4th August 2021

Application No: WA/63/21/PL
Site Address: Land East of Tye Lane Walberton BN18 0LU
Description of works: Proposed alternative vehicular accesses off Tye Lane and emergency access off Avisford Park Road, along with minor highway works following WA/95/18/RES (resubmission following WA/93/20/PL). This site is CIL Zone 2 (Zero Rated) as other development.

Thank you for your internet representation made on 3rd August 2021 which has been recorded as an objection with the comments as follows:

Drawing Title:
PROPOSED ALTERNATIVE ACCESS

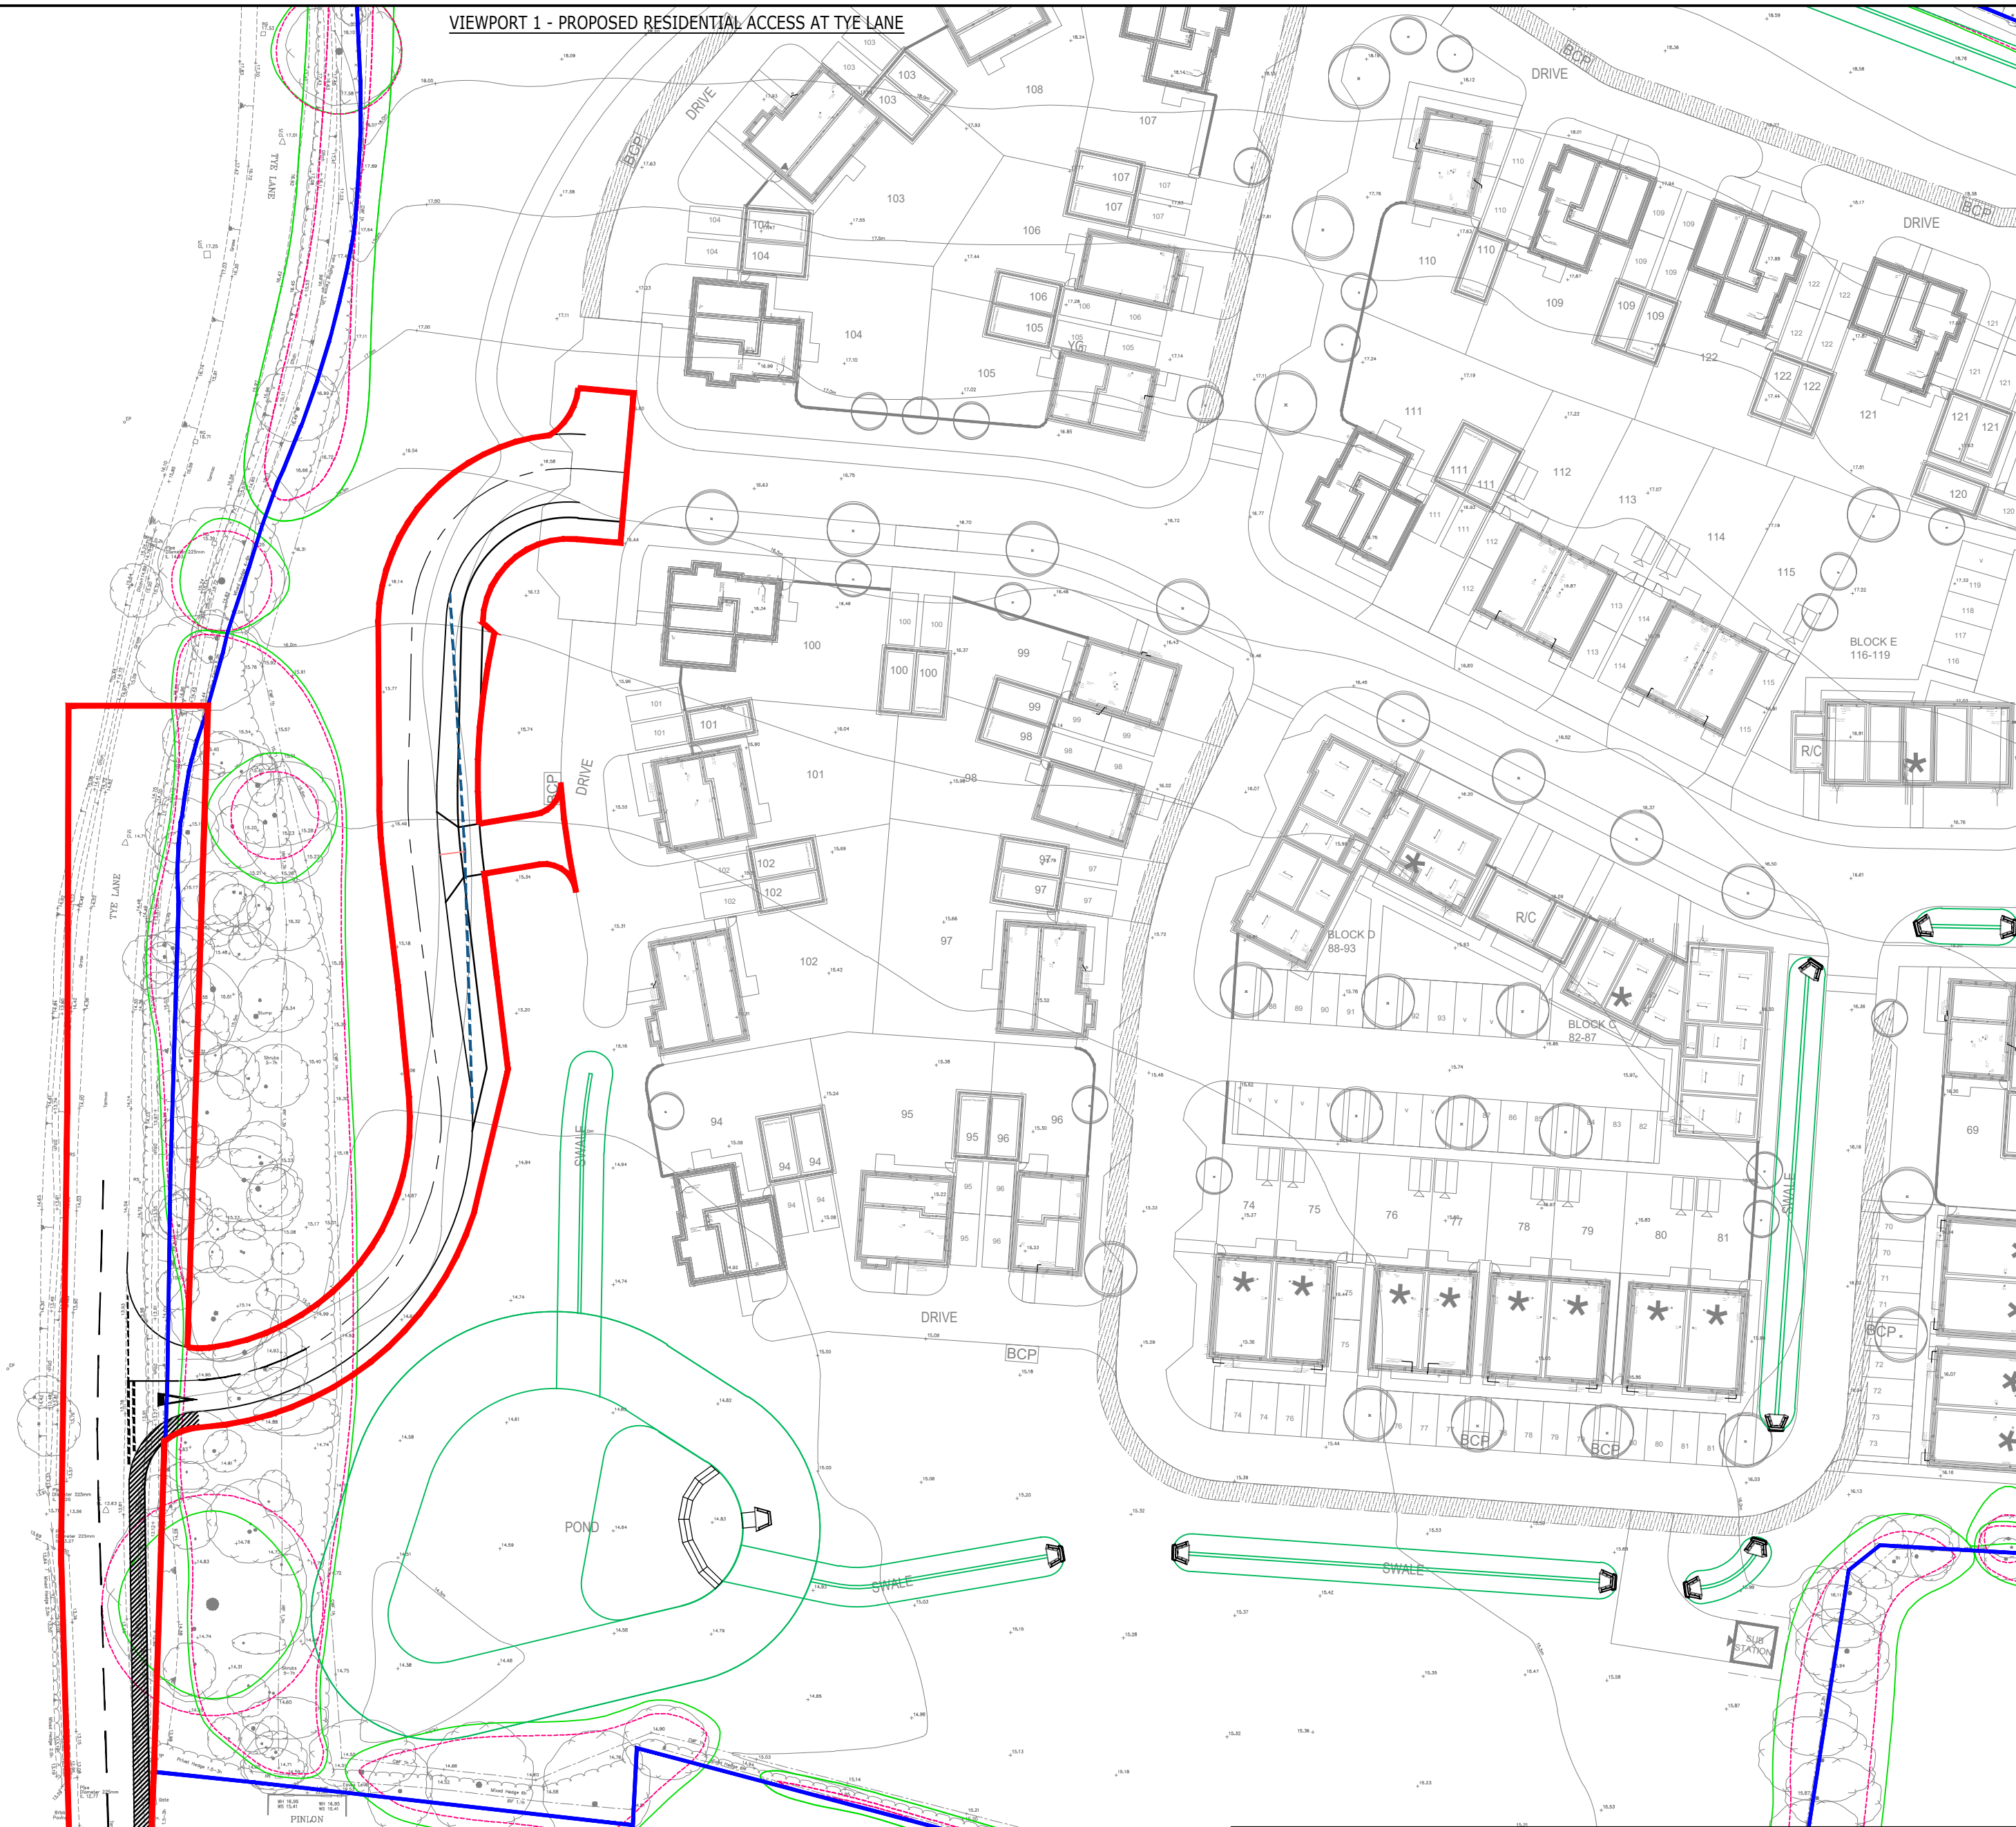
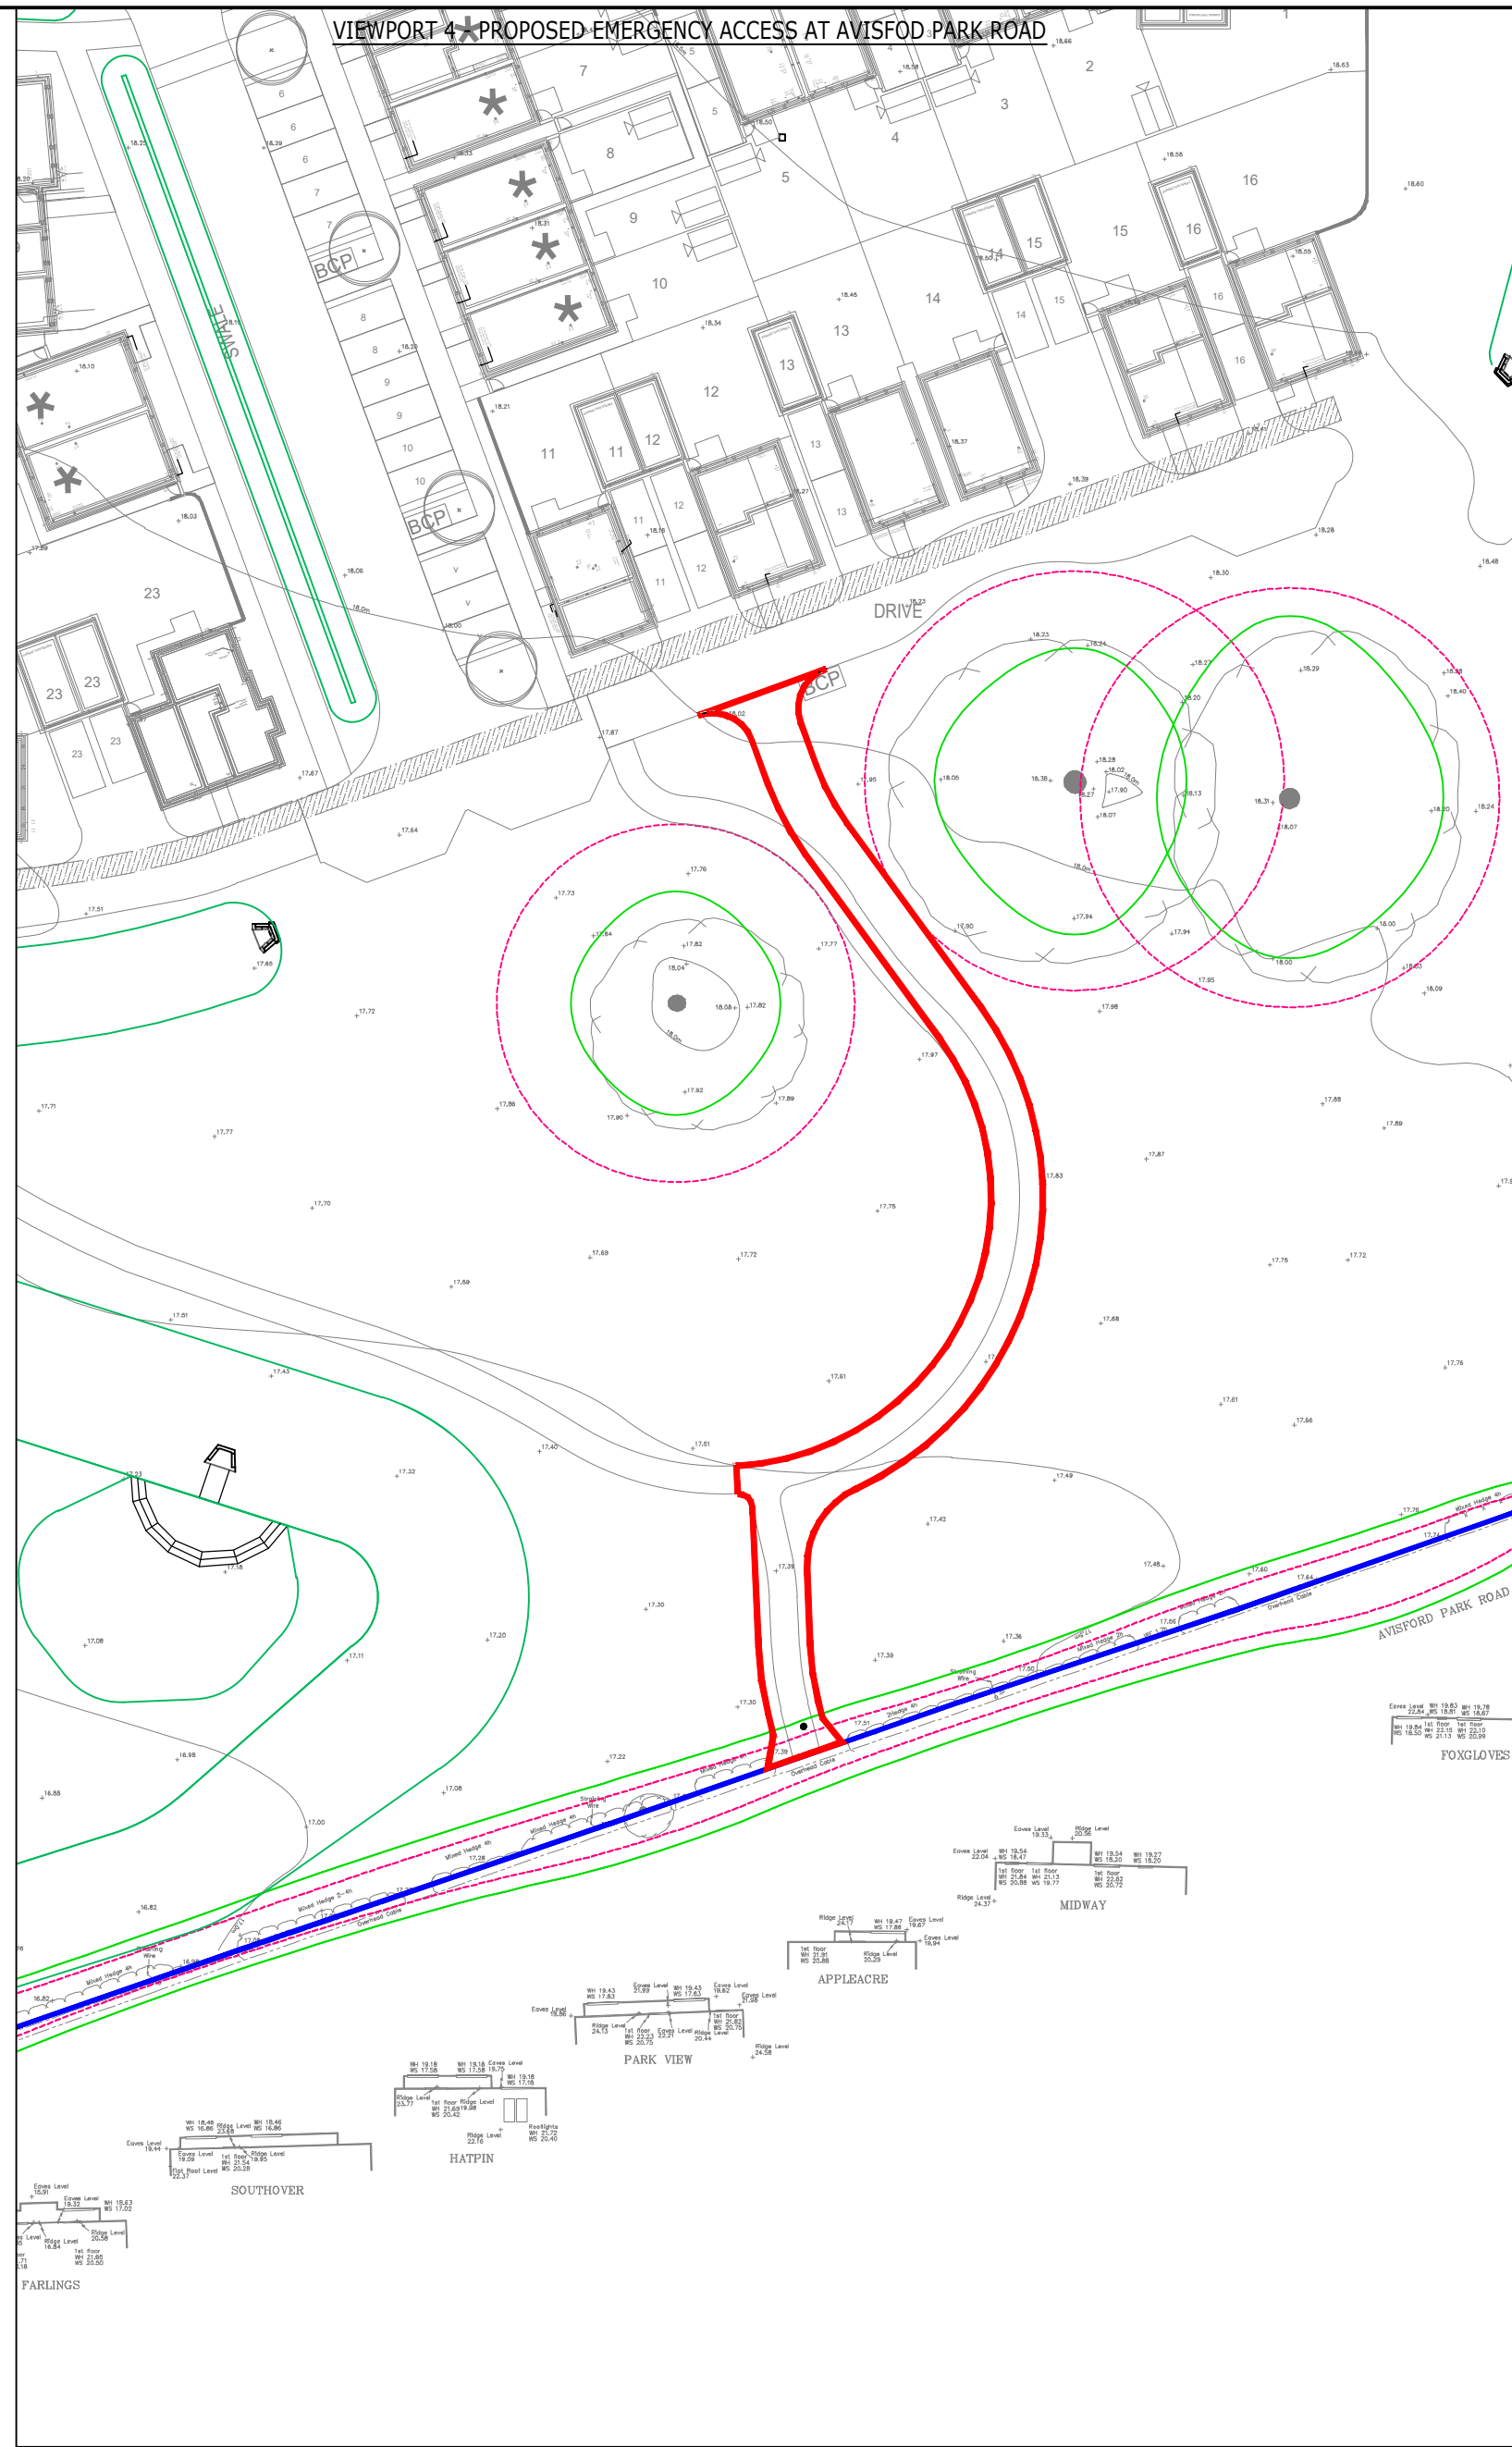
Tye Lane is significantly narrower than Yapton Lane for vehicle movements. The new application reduces Tye Lane to a minimum of 4.8m rather than 5.0m for approximately 25m which would mean that a HGV and a car could no longer pass at this point. 2 vans (2.4m wide) would be able to pass with zero clearance between vans and kerb and the vans themselves, encouraging vehicles to mount the pavement. 5 of the 6 houses at The Street end of Tye Lane have land ownership up to the current highway boundary. 2 of the houses do not have driveways or garages and cars are legally parked on the road further reducing safety if traffic along this road is to be increased. Parking on The Street can also impact on the visibility for vehicles pulling out into The Street at this junction.

The proposed cycle route from AG leads down this narrowed route which will pose increased risks to cyclist from traffic trying to pass them. The reduced road width to accommodate the new access point poses increased dangers to pedestrians, cyclists, horse riders and vehicular traffic.
